Our Ref: AR/207/IE
Your Ref: P/25/18/PL
Email: [REDACTED]
Date: 23 April 2018
Status: By post and email

APPLICATION P/25/18/PL - DEMOLITION OF EXISTING GARAGE, ROOF ALTERATIONS TO EXISTING DWELLING TO PROVIDE FIRST FLOOR & NEW DWELLING IN GARDEN JENIN, NYETIMBER LANE, PAGHAM, WEST SUSSEX PO21 3JT

Peter J. Gardner Architectural Design Consultant	
	www.architecturaldesignsolutions.co.uk 07967 205249
Job Title	Jenin, Nyetimber Lane Bognor Regis PO21 3JT
Drawing Title	Proposed New Dwelling Floor Plans
Client	R.B
Date	12/05/2017
Drawn	P.J.G
Scale	1:100 on A3
Drq No.	NTL/P/01

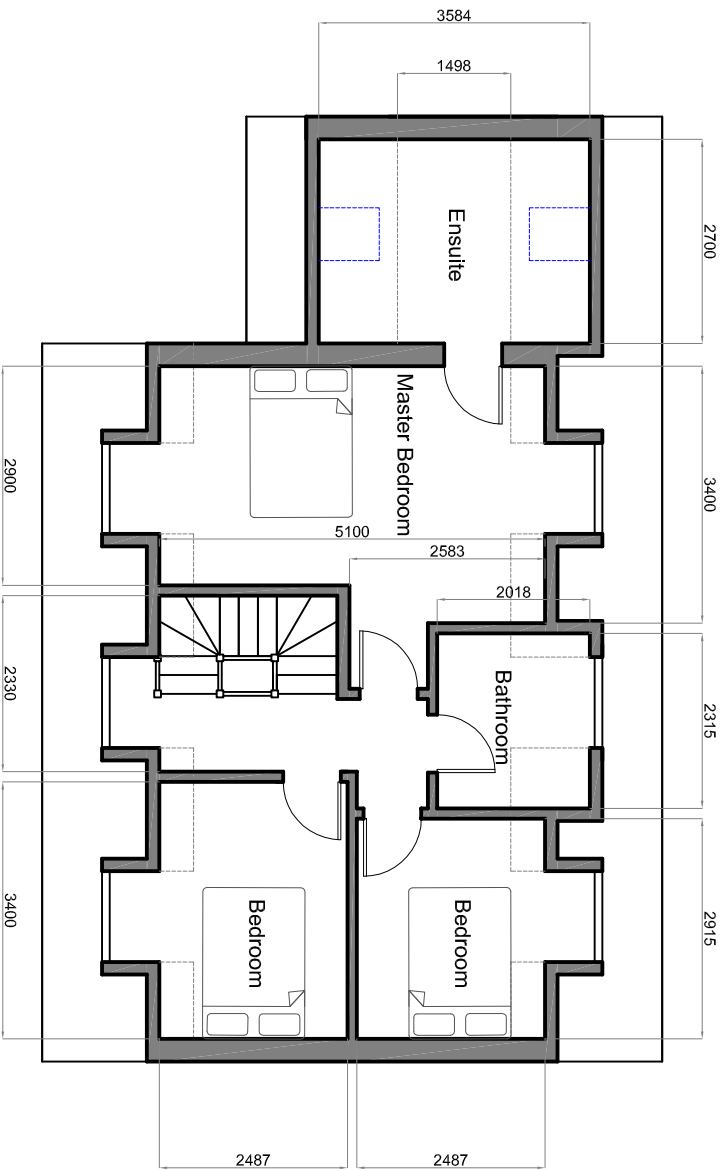
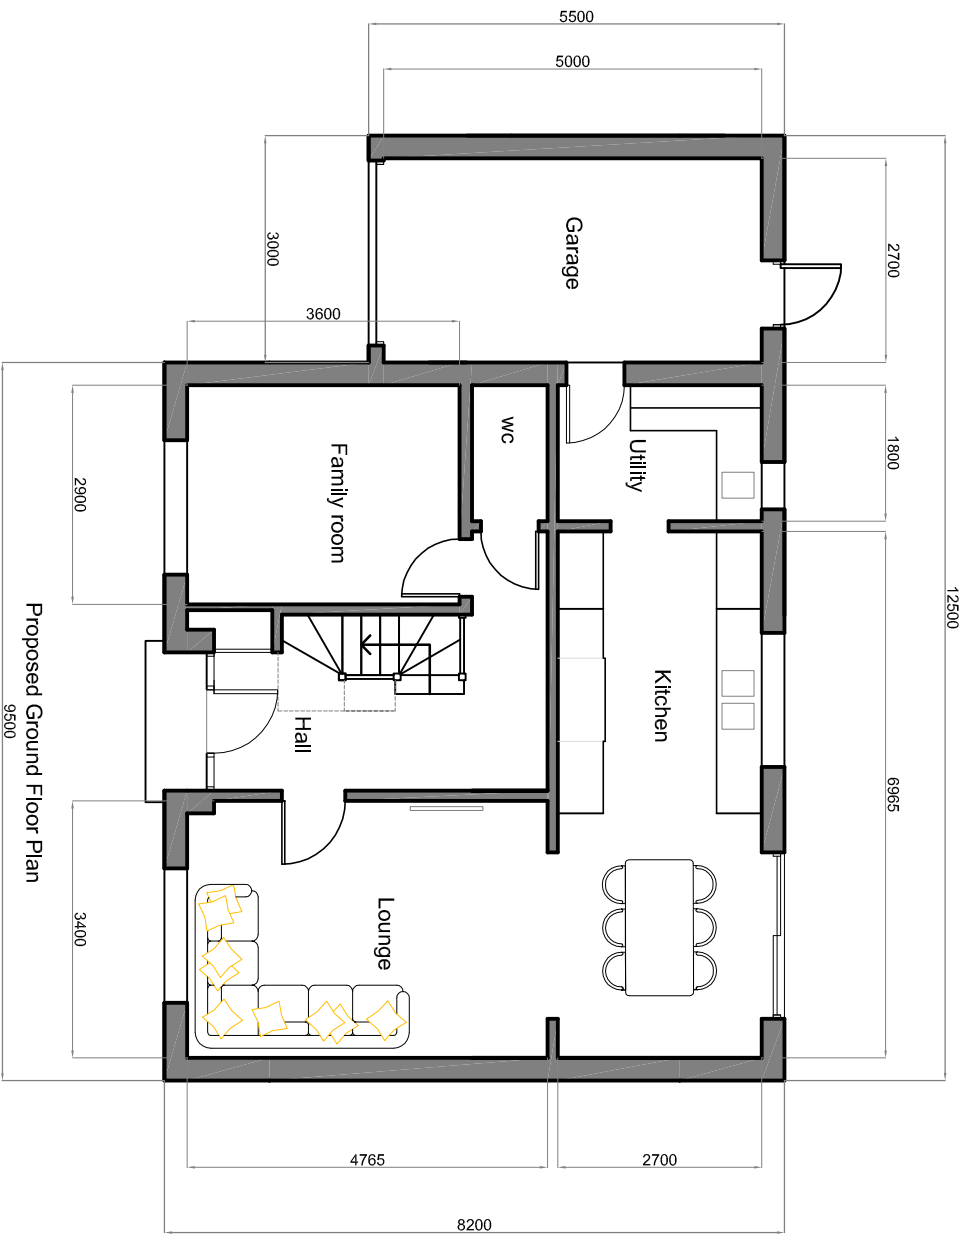
- The proposed two storey dwelling will be out of place in this out of the way cul-de-sac and if permitted would be in stark contrast to the understated built form of the properties in Priors Way. Moreover the proposed dwelling would dominate the adjacent dwelling Llamedos by reason of it being sited forward of the immediate front wall of Llamedos.

The dwelling will be a dominant addition to the understated built form in Priors Way with accommodation on two floors and a bulk and height forward on the plot dominating the Way in a way that is completely absent from the existing dwellings in Priors Way. As a result the height and bulk of the dwelling will be unacceptably dominant in the streetscene.

Job Title		Jenin, Nye/timber Lane Bognor Regis PO21 3JT			
Drawing Title	Block Plan Proposed				
Client	R B				
Date	12/05/2017				
Drawn	P.J.G				
Scale	1:500 on A3				
Dwg No.	NT/L/BP/02				B

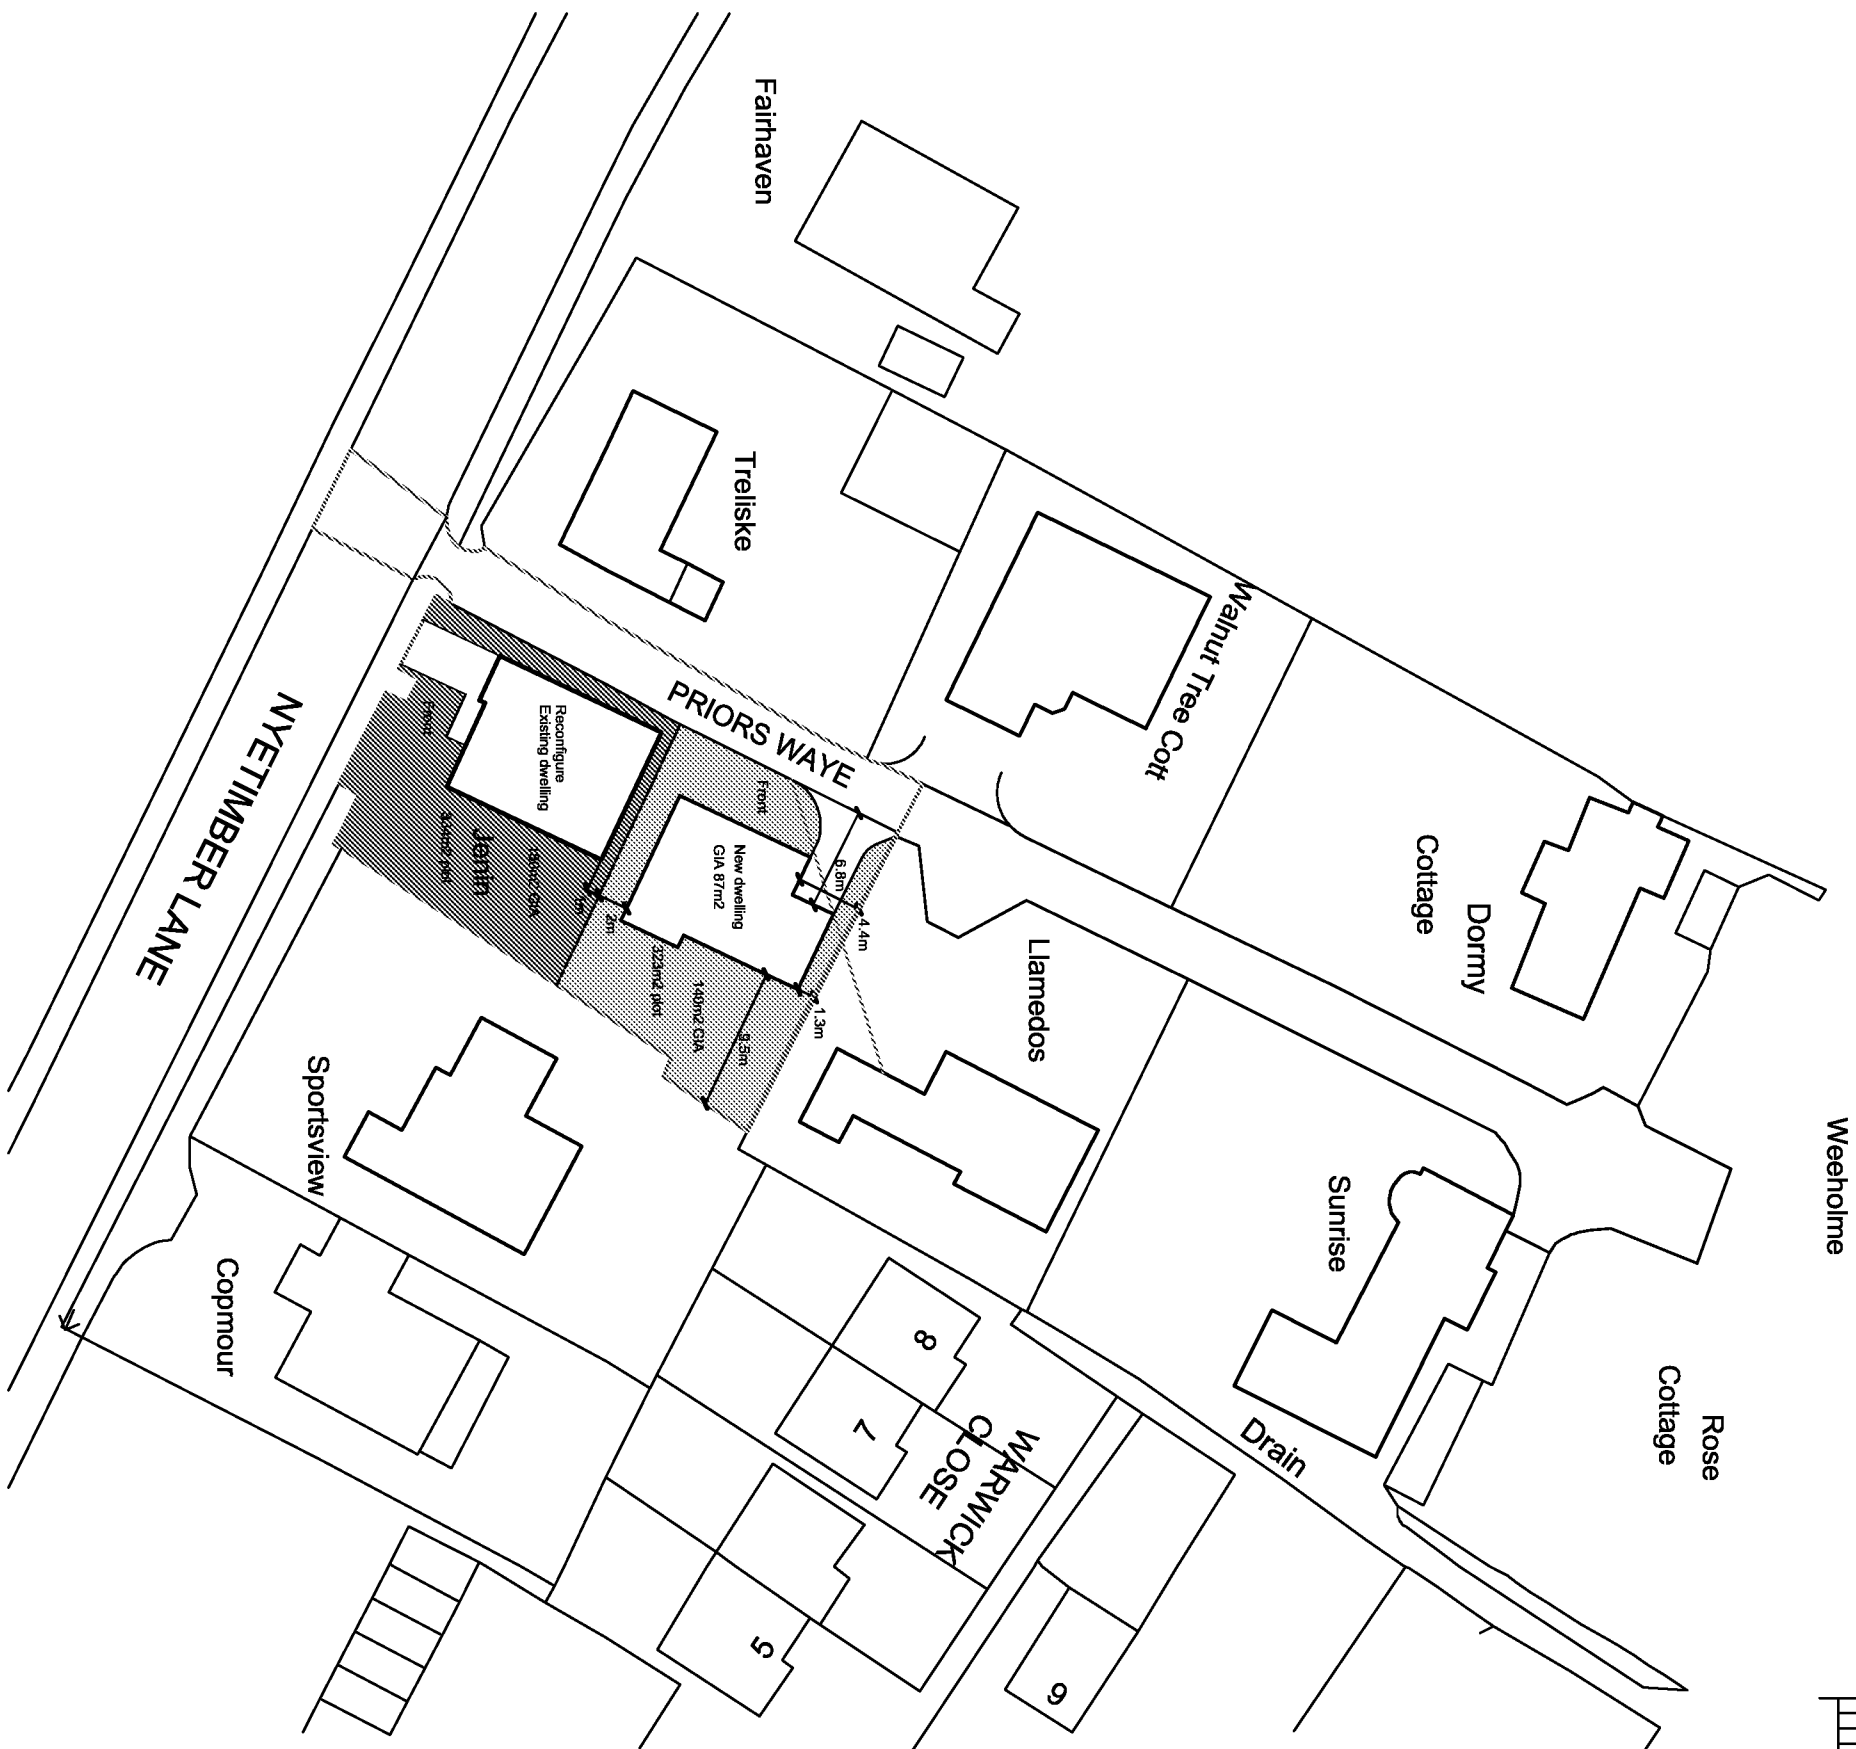
The proposed new dwelling would occupy 323m² - just under half of the curtilage of Jenin. It would be sited approximately 4m back from the side frontage with Priors Way and be a minimum of 6.5m from the rear boundary with Sportsview. On plan it has every appearance of being crammed into the site giving rise to the first concern that it amounts to overdevelopment of the site. This is reinforced by comparison with the size of adjacent curtilages which show that the average curtilage size is some 760m².

- Importantly Jenin has no right of access over Priors Way and the introduction of an additional access to and traffic on the cul-de-sac will have an unacceptable adverse impact on the residential amenity of properties in Priors Way. The proposed access is at a point in the road where the available width is only 3m (not the 5m claimed) at a point where the users of that access will cause inconvenience to traffic entering and leaving both Llamedos and Walnut Tree Cottage opposite.
